WEST SUSSEX COUNTY COUNCIL CONSULTATION

TO:	<u>Arun</u> District Council <u>FAO:</u> Anita Gardner
FROM:	<u>WSCC</u> - Highways Authority
DATE:	29 April 2019
LOCATION:	The Nelson Hotel, 61, Pier Road, <u>Littlehampton</u> , <u>BN17 5LP</u>
SUBJECT:	<u>LU/324/18/PL</u> Demolition of existing hotel & replacement with new 14 bedroom hotel with ancillary restaurant & function rooms. Amendment received.
DATE OF SITE VISIT:	
RECOMMENDATION:	Advice
S106 CONTRIBUTION TOTAL:	£ N/A

BLOCK PLAN(1:500)

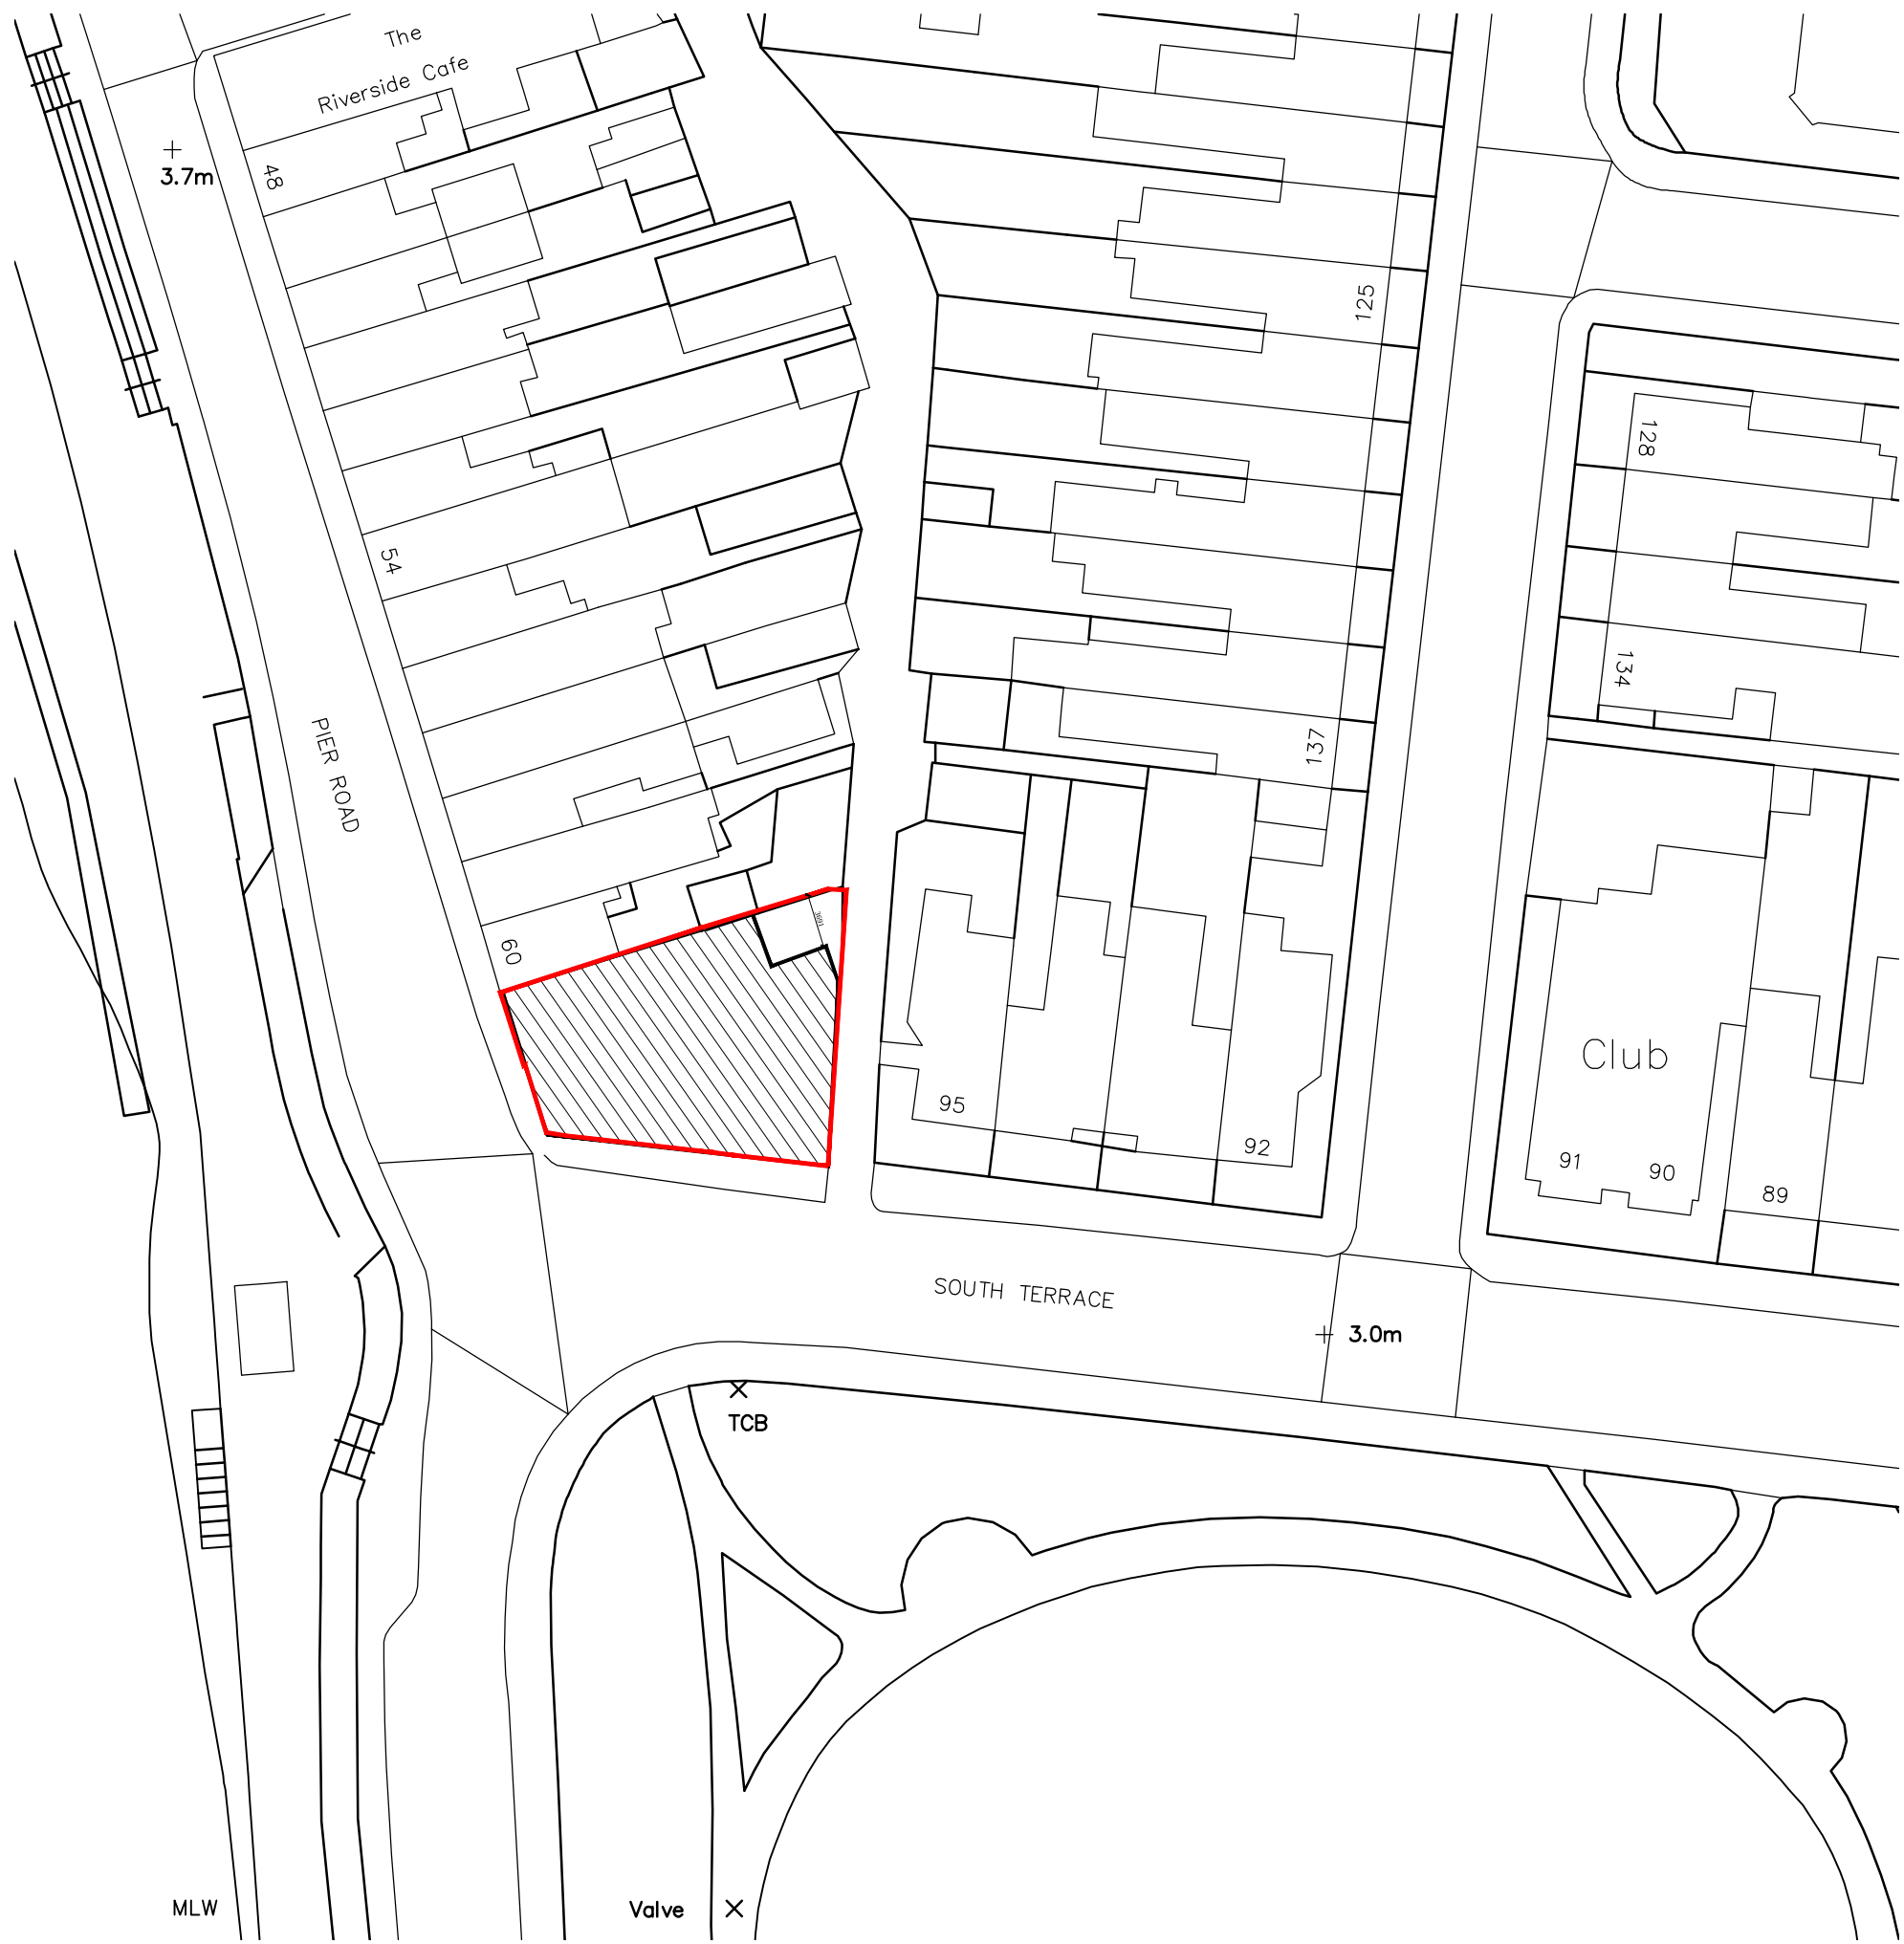
Upon comparing the plans with WSCC mapping data the design does not appear to encroach onto the publicly maintained highway or narrow the existing footway. There is a triangular piece of land on the south western boundary which is to be utilised by the site, this is within the red edge of the property boundary and would be utilised as an access area. Similarly a triangular portion of land is present on the south eastern property boundary this also within the red edge of the applicant, either of these portions of land appear to overlap the publicly maintained highway.

The applicant is advised that any works within the publicly maintained highway are prohibited without either obtaining the relevant license or without stopping up and rescinding the highways rights over the land.
